A1 Birtley to Coal House

Scheme Number: TR010031

Statement of Common Ground with Gateshead Council

Version	Date	Status of Version
Rev 1	20 April 2020	Draft

HE551462-WSP-LLO-ZZ-X-DR-GI-5003

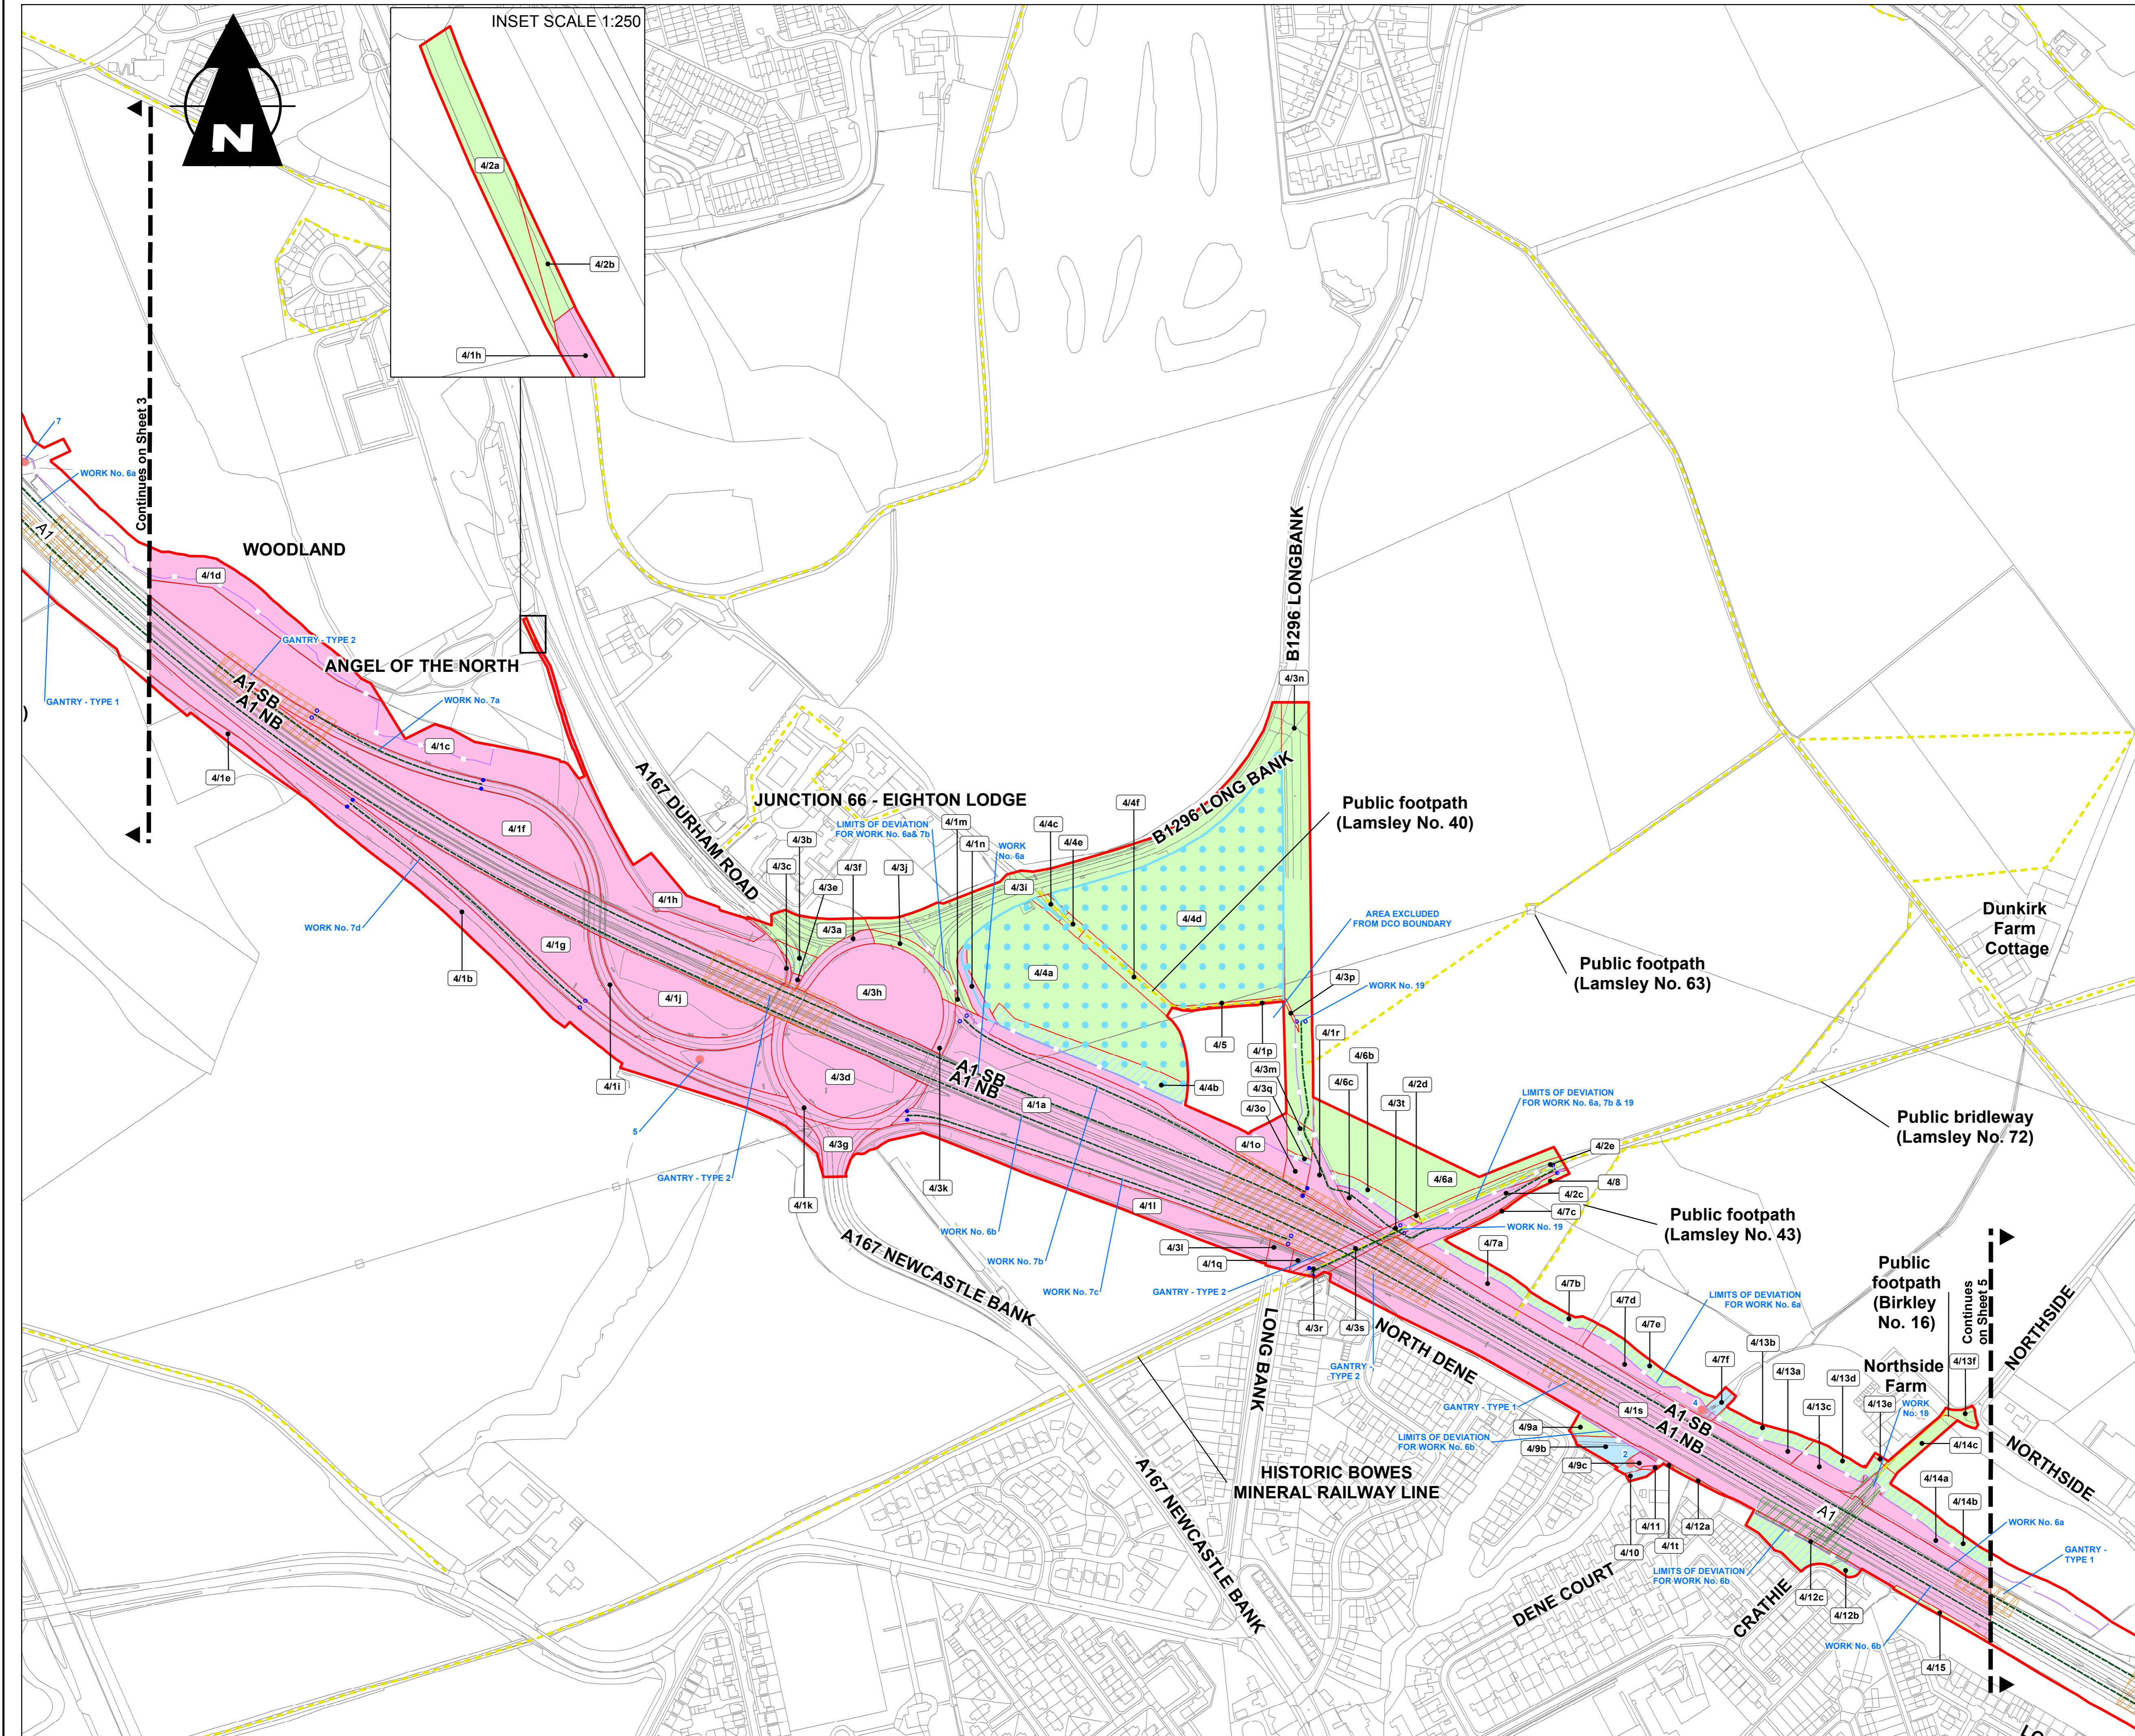
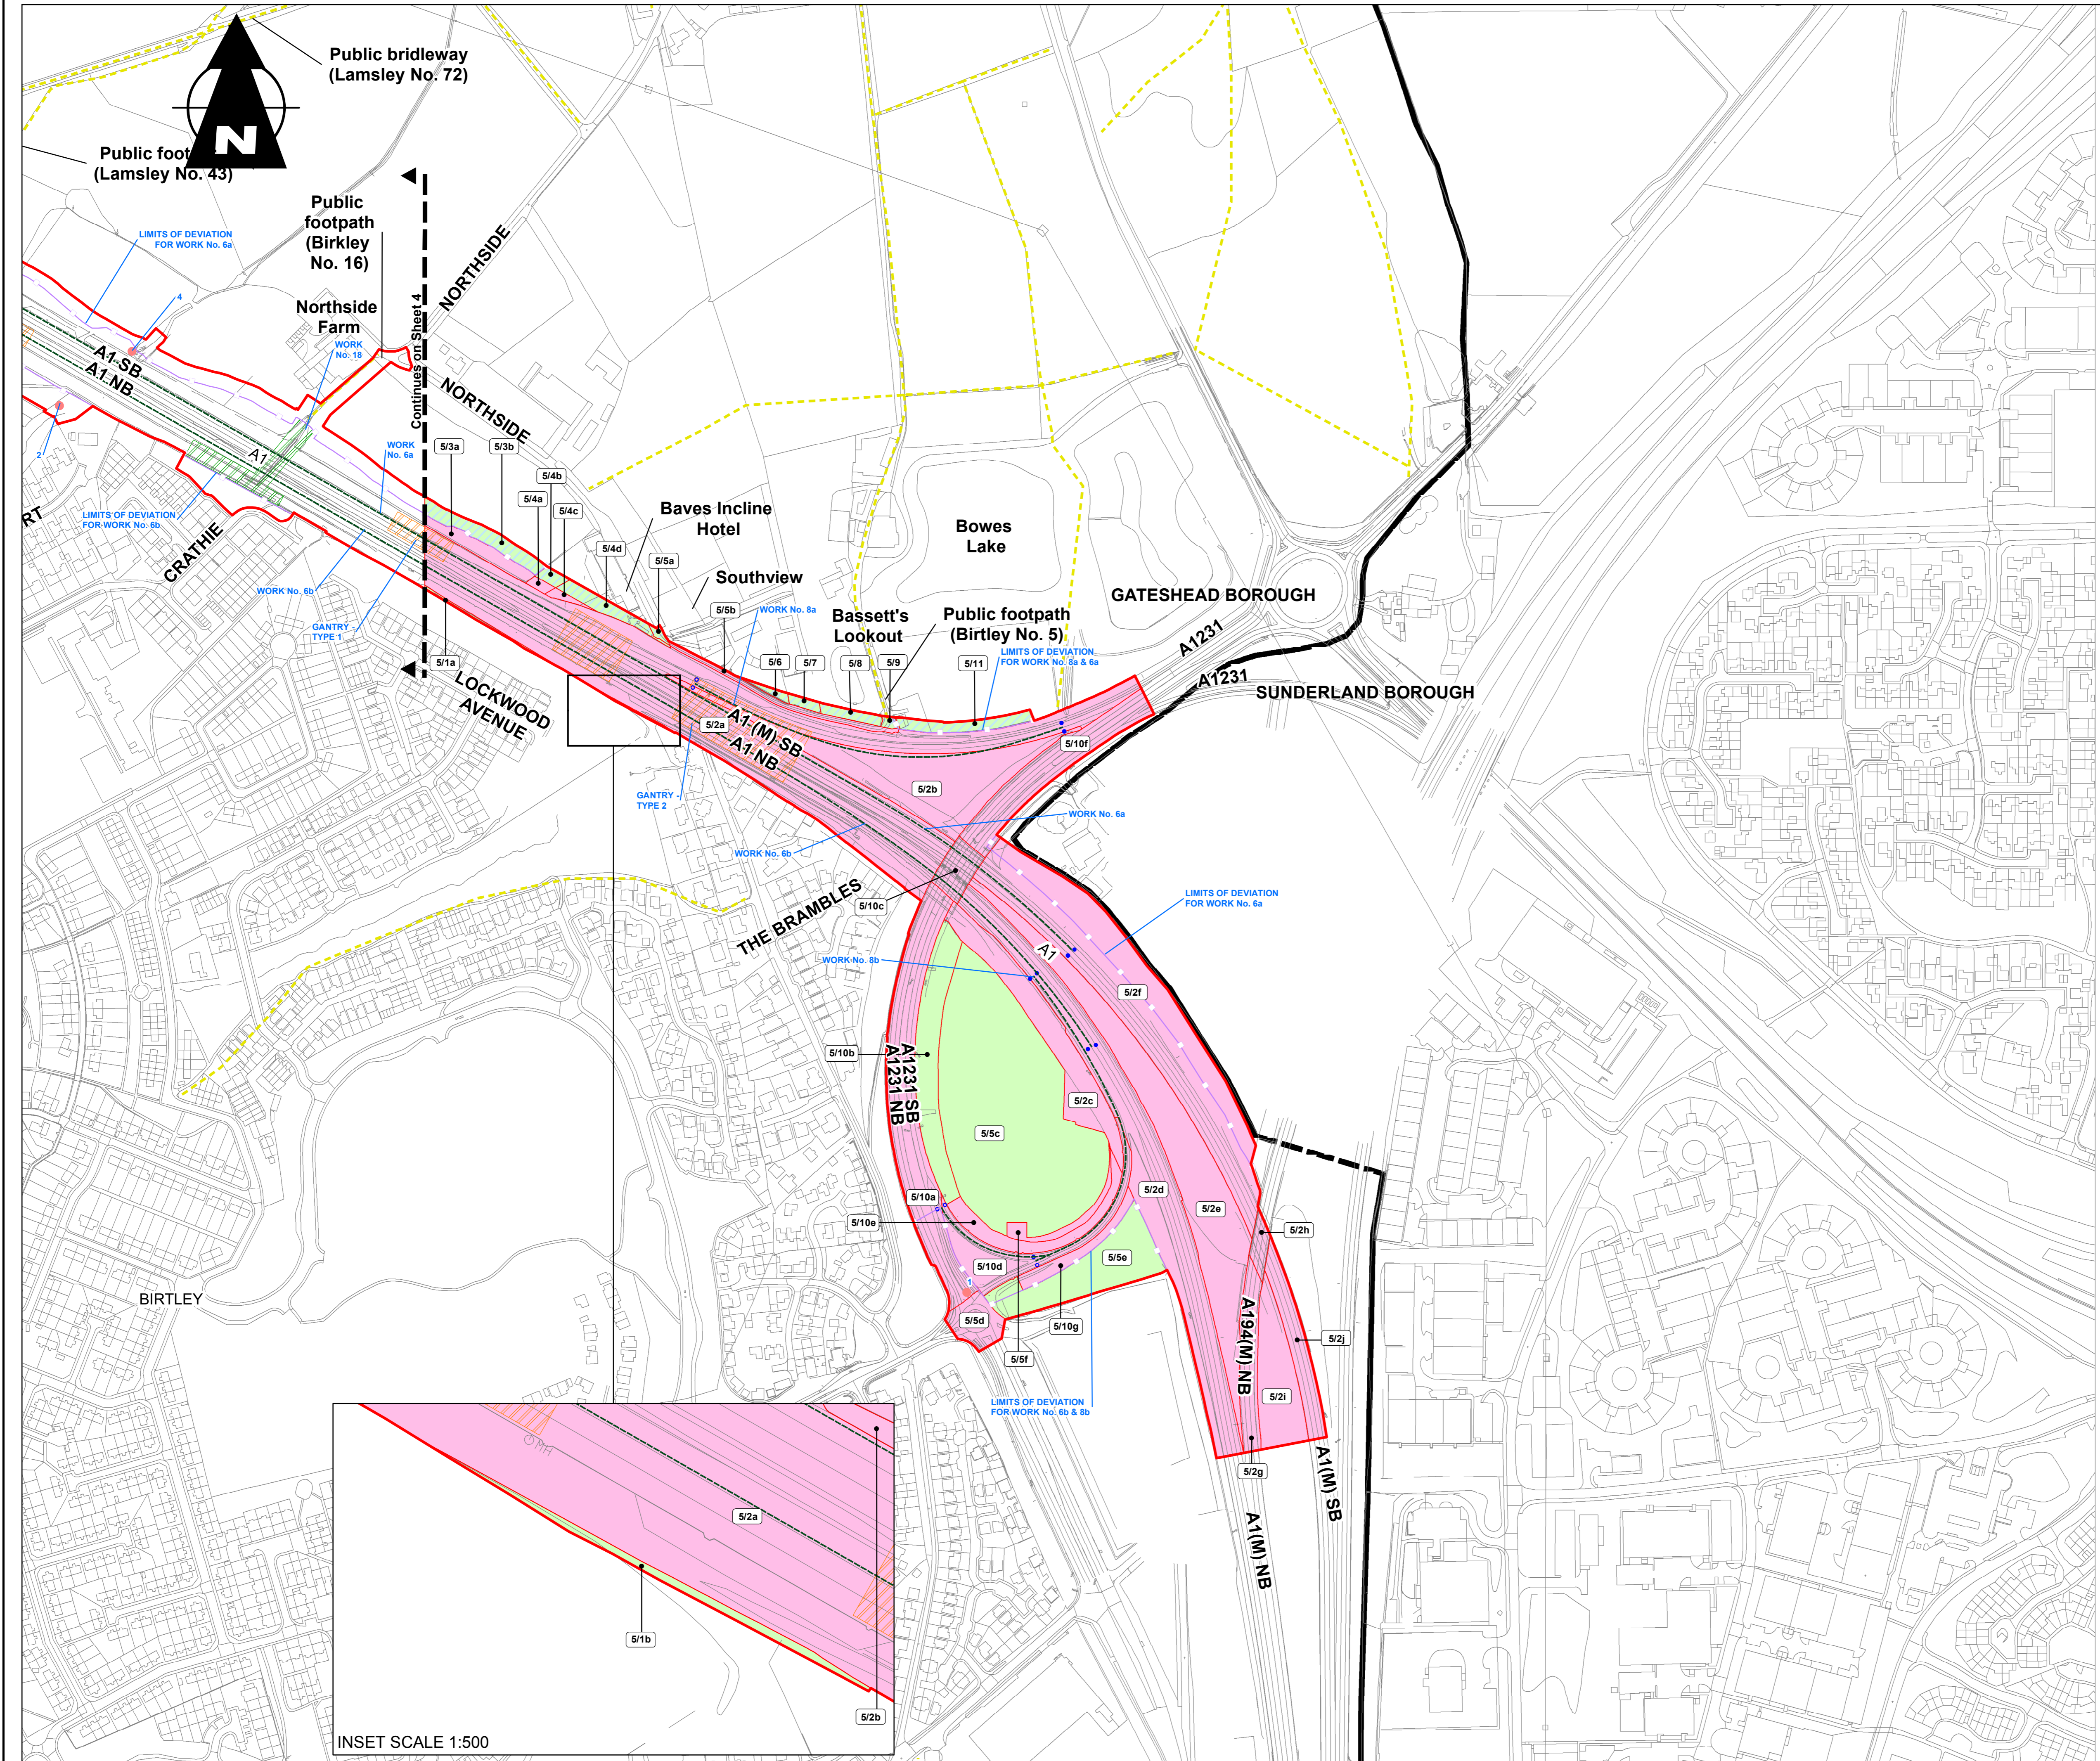
Section	Sub-section	Gateshead Council Position	Highways England Position	Status
			Details are currently under discussion with Gateshead Council.	
Works Plans [APP-007]	Sheets 3, 4, 5, 6 & 7	Under discussion post DCO decision. Workshop to be arranged prior to Deadline 3	Gantries will be provided along the Scheme, although at this stage, their locations along the Scheme are not fixed to allow flexibility in later design stages. Further details of current proposals have been included in Appendix 2.0B Gantry Report [EXA/D4/015] of the Applicant's responses to the ExA's Second Written Questions submitted at Deadline 4. A telephone conversation was held with Clare Richardson from Gateshead Council on 24 March 2020. A further call between WSP and Gateshead Council was held on the 10 April 2020 to get feedback from Ecology, heritage and Landscape officers. This has informed further development of the design of the interface between the Angel of the North and the Scheme.	Under Discussion
